A46 Newark Bypass

Scheme Number: TR010065

**Statement of Common Ground with
Newark And Sherwood District Council**

Regulation Number:	8(1)(e)
Planning Inspectorate Scheme Reference	TR010065
Application Document Reference	7.30
Author:	A46 Newark Bypass Project Team, National Highways

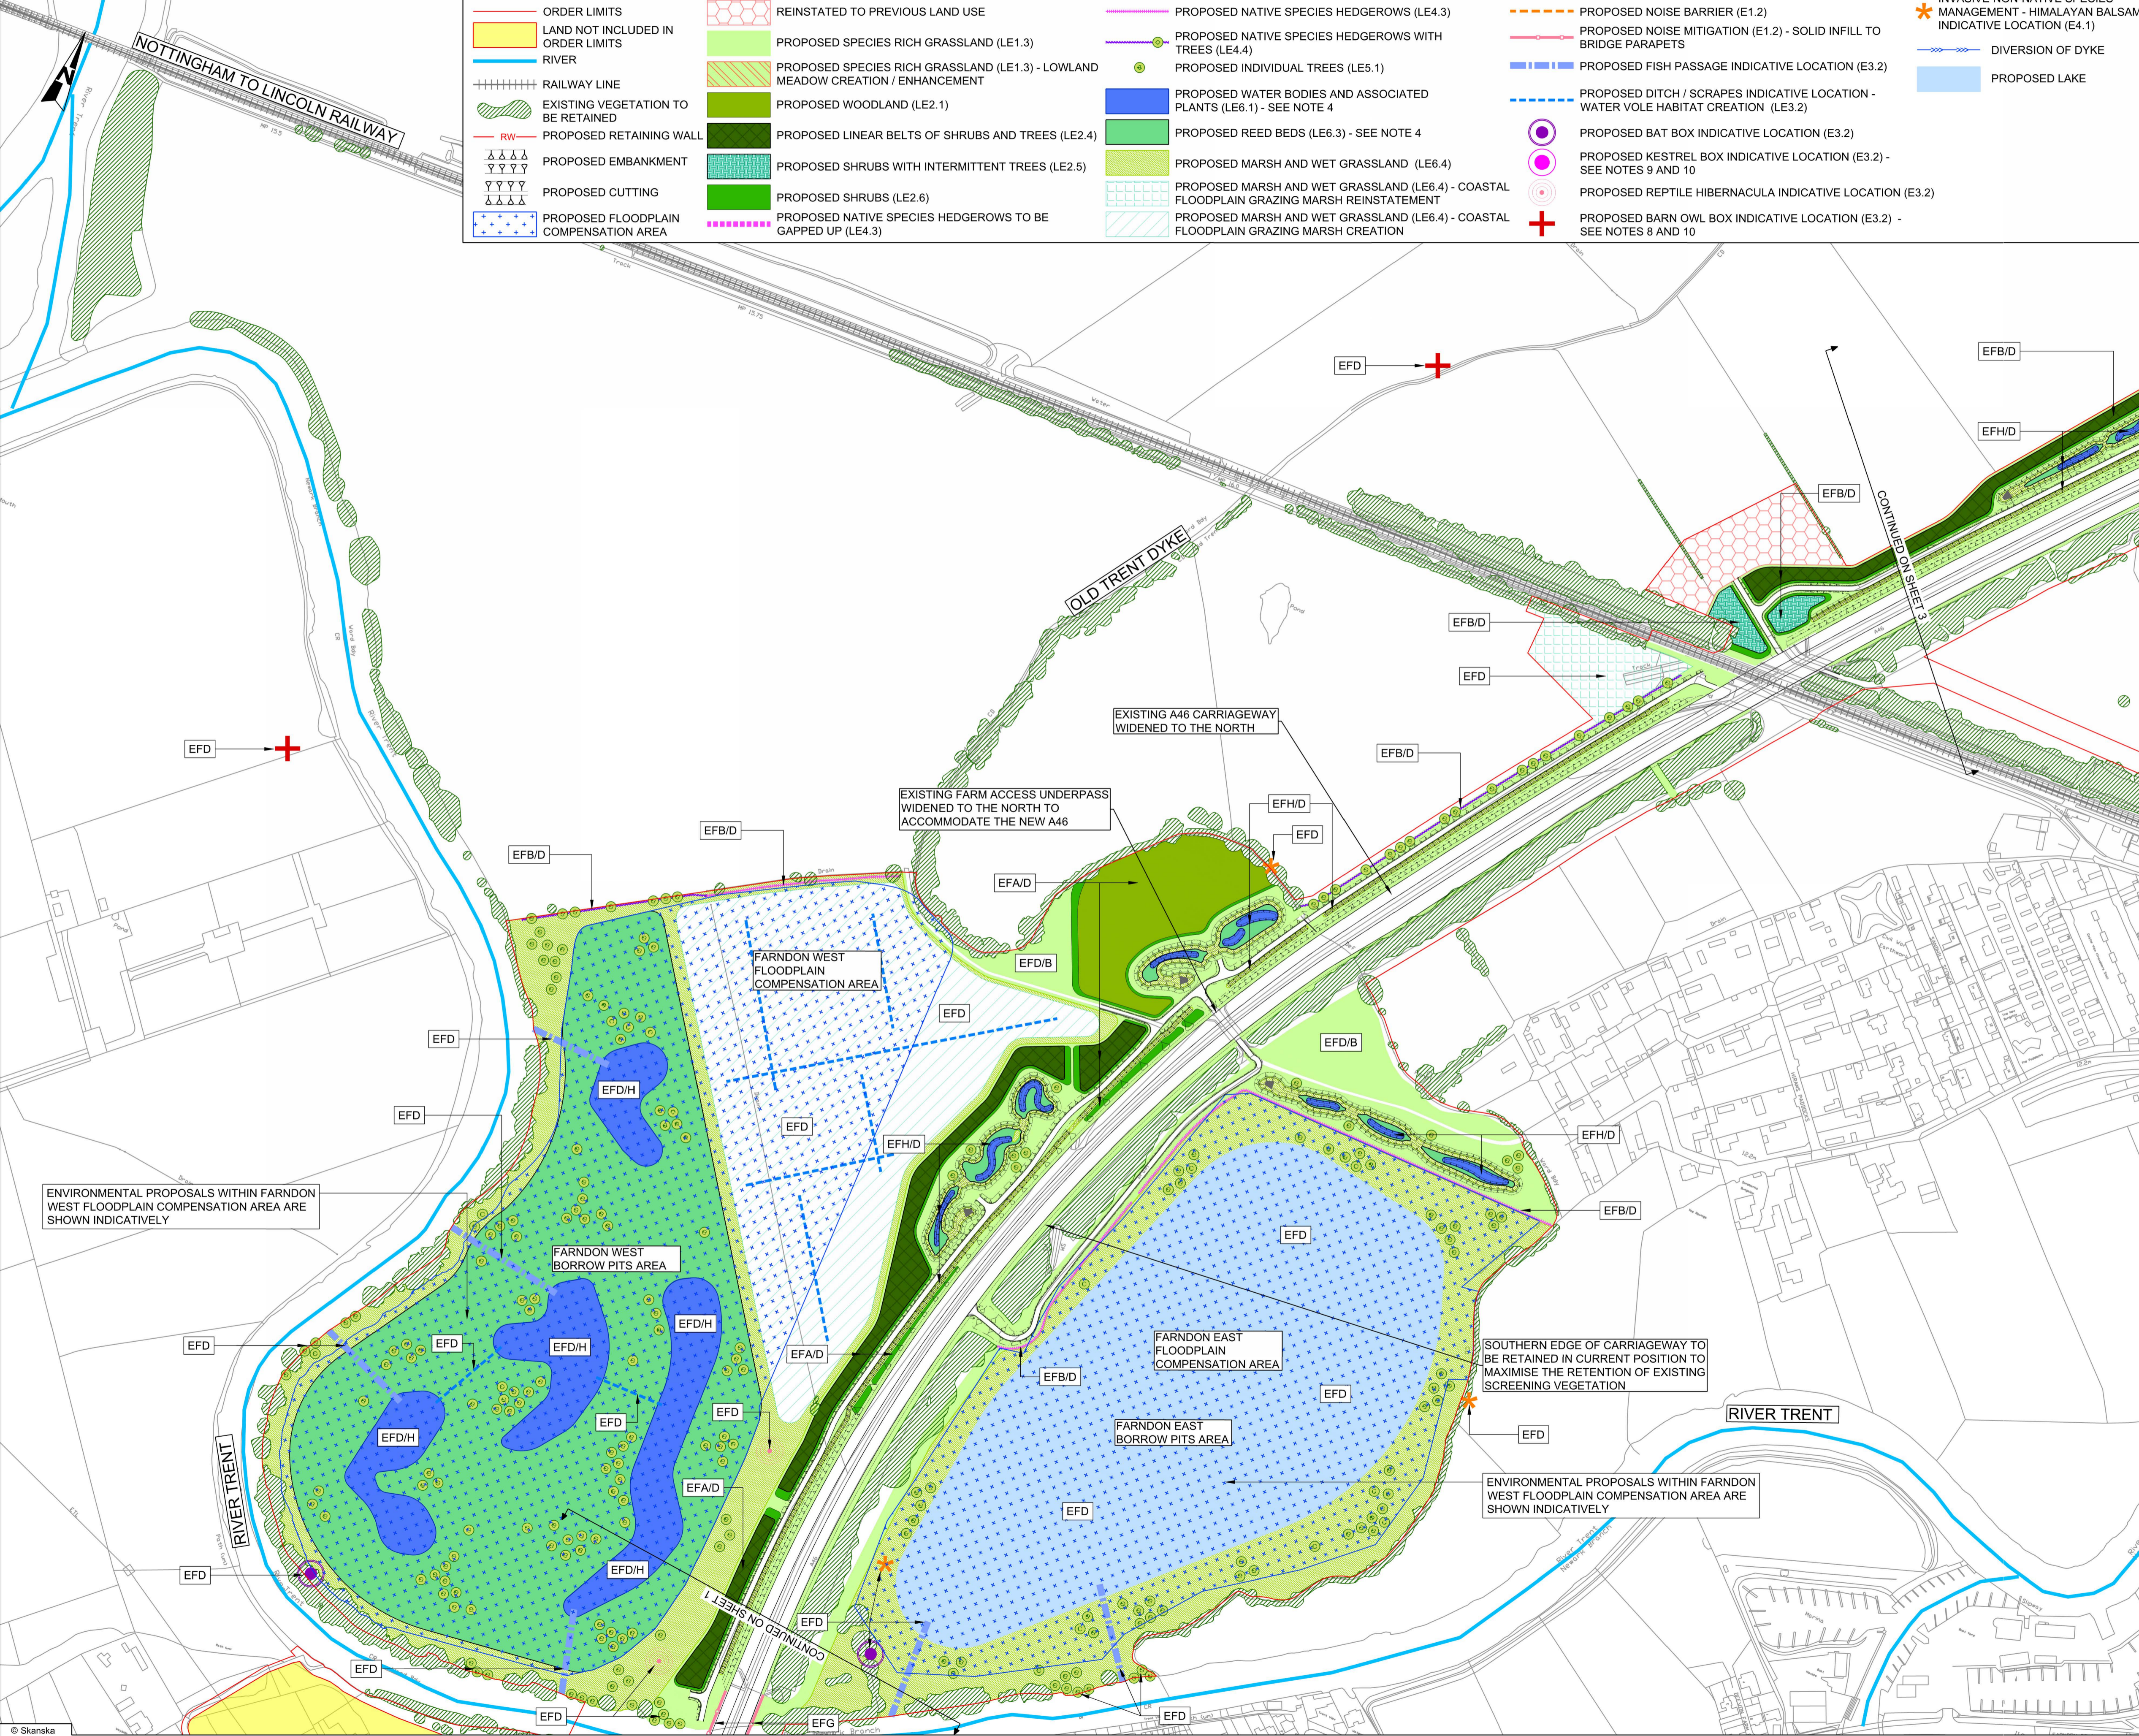
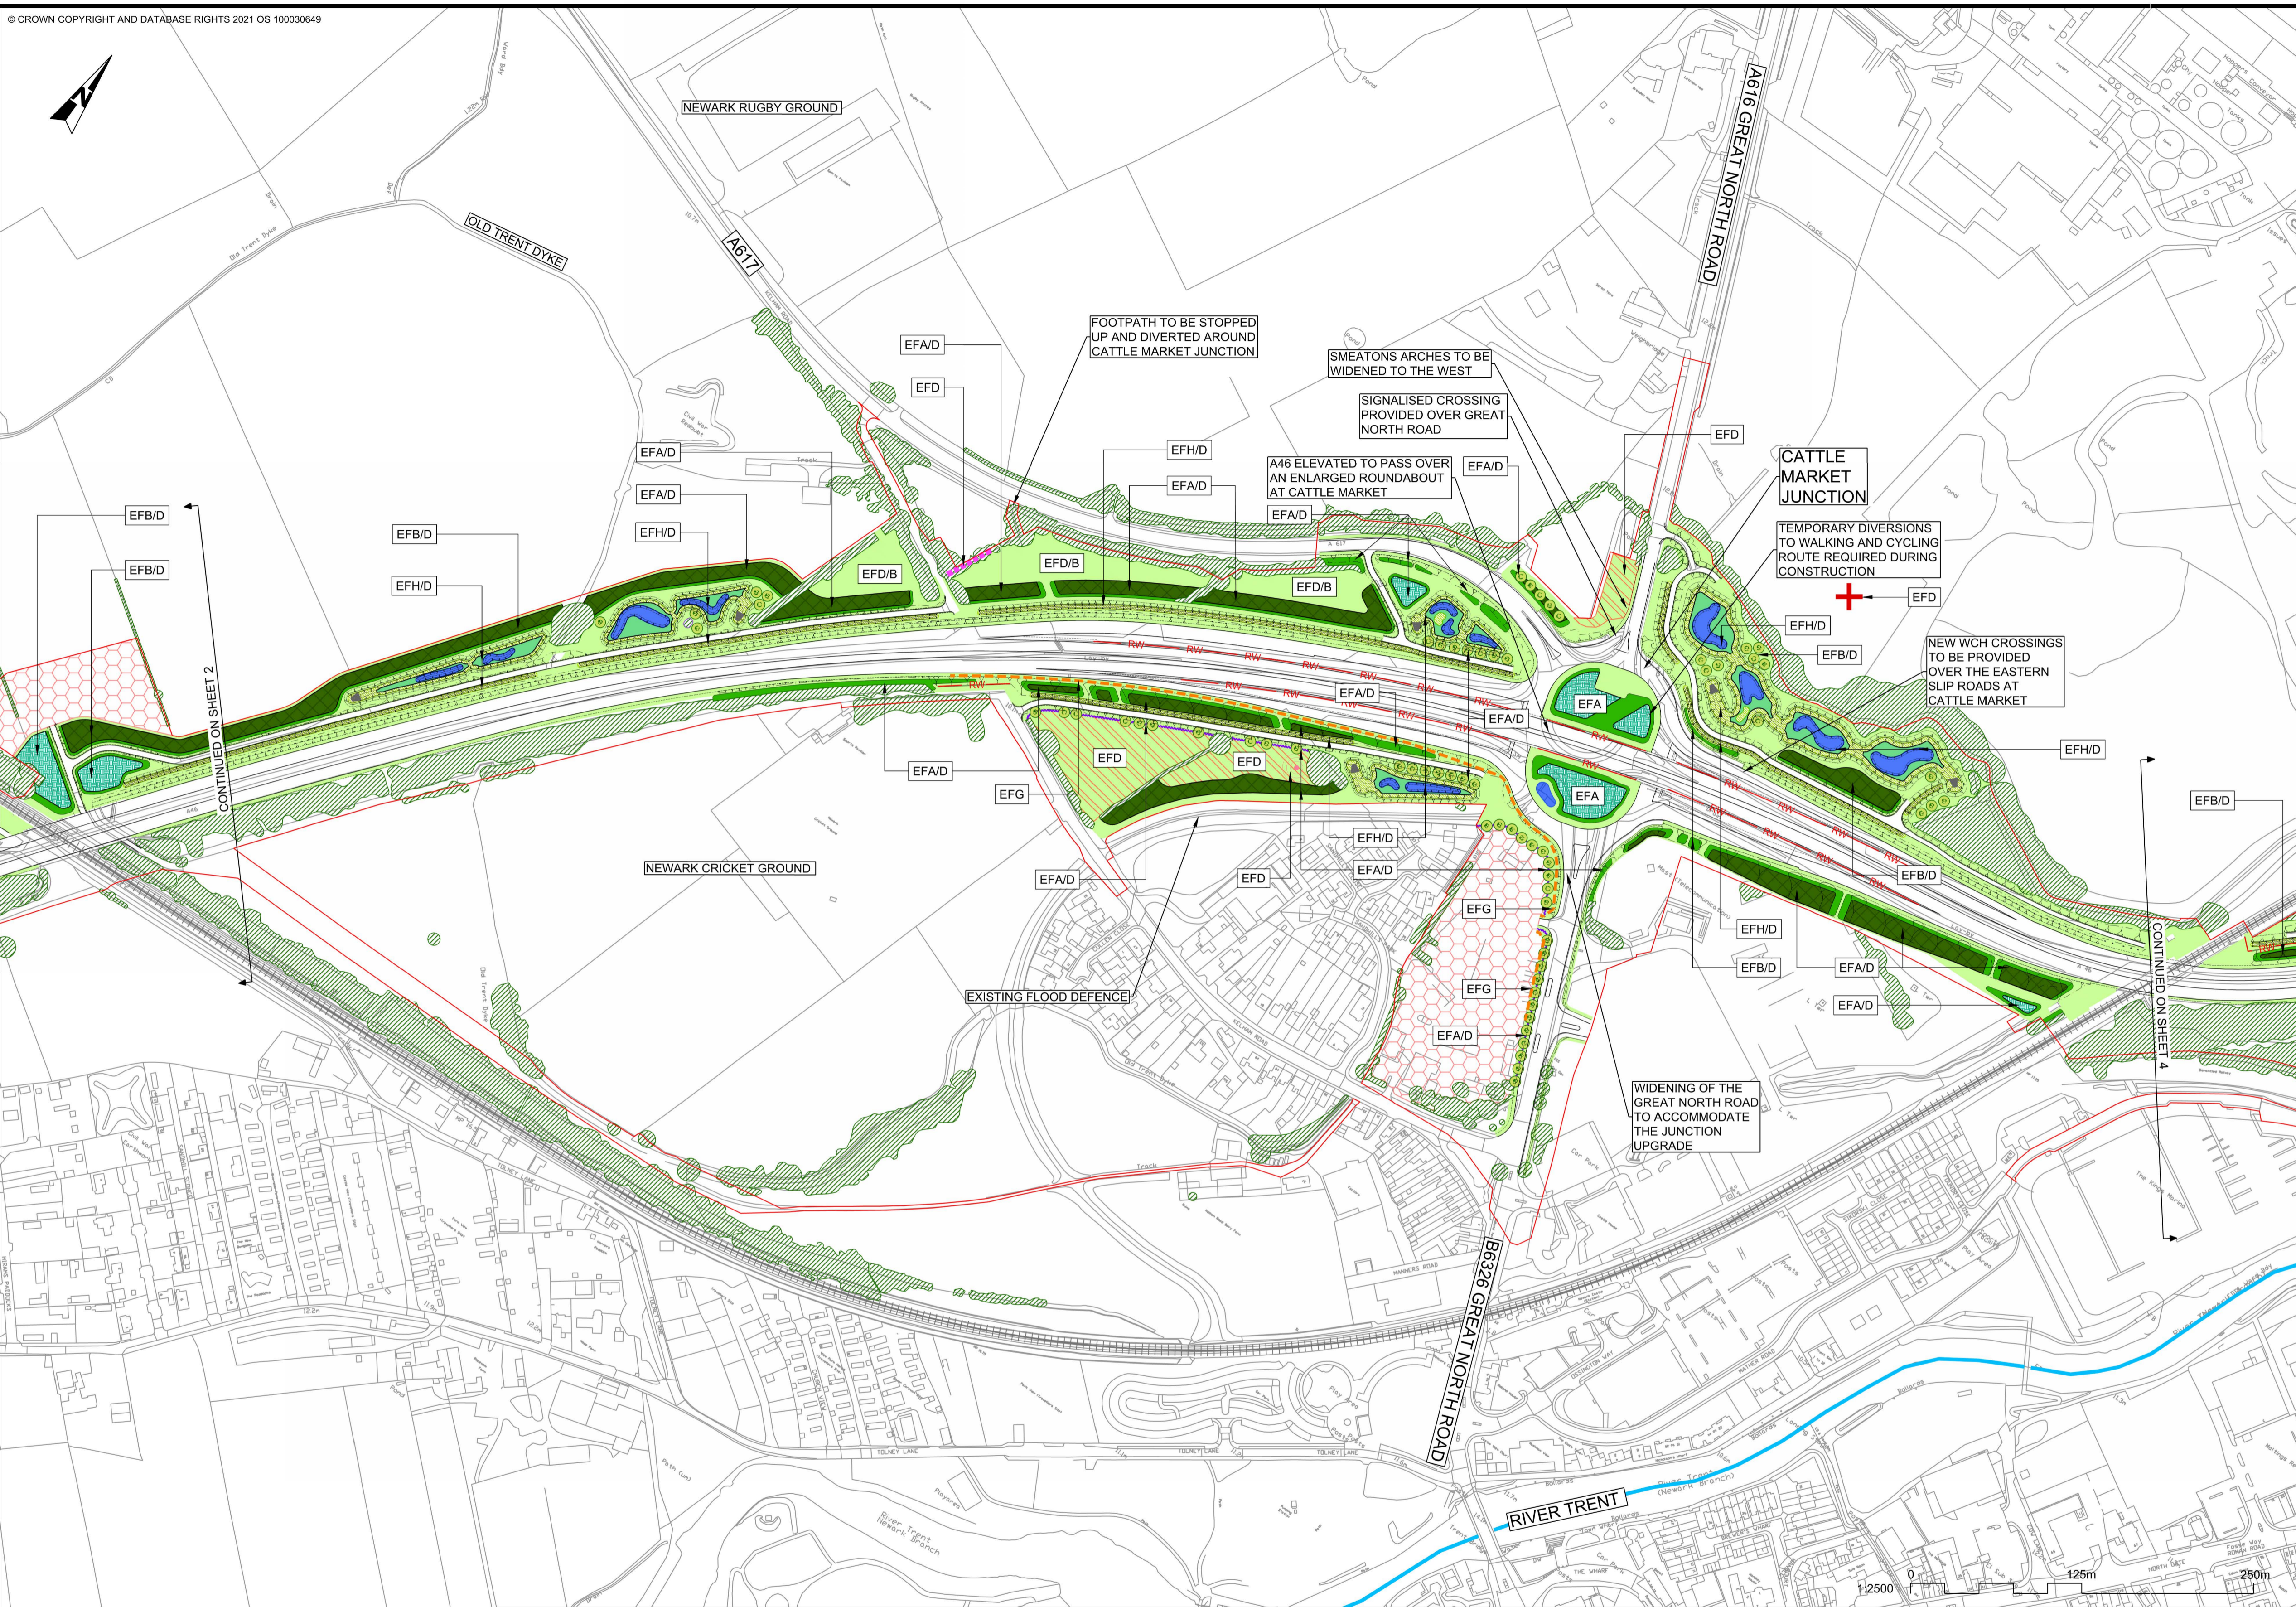
10.	Design (including justification for any flexibility being sought)	Chapter 2 The Scheme of the Environmental	<p><u>Cattle Market flyover</u></p> <p>On the fly-through video the structure of the elevated over-pass at the Cattle Market junction appears as a stark and imposing concrete structure. This may be</p>	<p>Consideration has been given to the aesthetic finish of the structure during the design development to help to reduce the visual prominence of the structure and to reflect finishes on existing structures such as that of Smeaton's Arches just to</p>	Under Discussion	16/10/2024

Issue No.	Issue	Document Reference	Newark and Sherwood District Council's Position	The Applicants Position	Status	Date status confirmed
		Statement [APP-046] 6.2 Environmental Statement - Figure 2.3 Environmental Masterplan [AS-026]	in part due to the animation which depicts it as being very bright in colour and therefore standing out vividly. The Council would want to understand proposals to ensure the visible impact of the final structure is minimised and/or mitigated as far as practicable.	the north of the new junction. Further details of these can be found within Chapter 2 The Scheme of the Environmental Statement [APP-046] and 6.2 Environmental Statement - Figure 2.3 Environmental Masterplan [AS-026]. Planting of trees and shrubs has also been considered and incorporated wherever feasible to help break up the visual mass of the structure, with planting softening the built form and aiding screening over time, particularly from properties such as those in Sandhills Park affording near distance views. The assessment of landscape and visual effects and associated design and mitigation measures are described in 6.2 Environmental Statement - Figure 2.3 Environmental Masterplan [AS-026] and presented in 6.2 Environmental Statement - Figure 2.3 Environmental Masterplan [APP-026]. Part of the Detailed Design process will be to define the finish of the retaining walls forming the Cattle Market Flyover. This will be a masonry type façade and not a bare concrete finish.
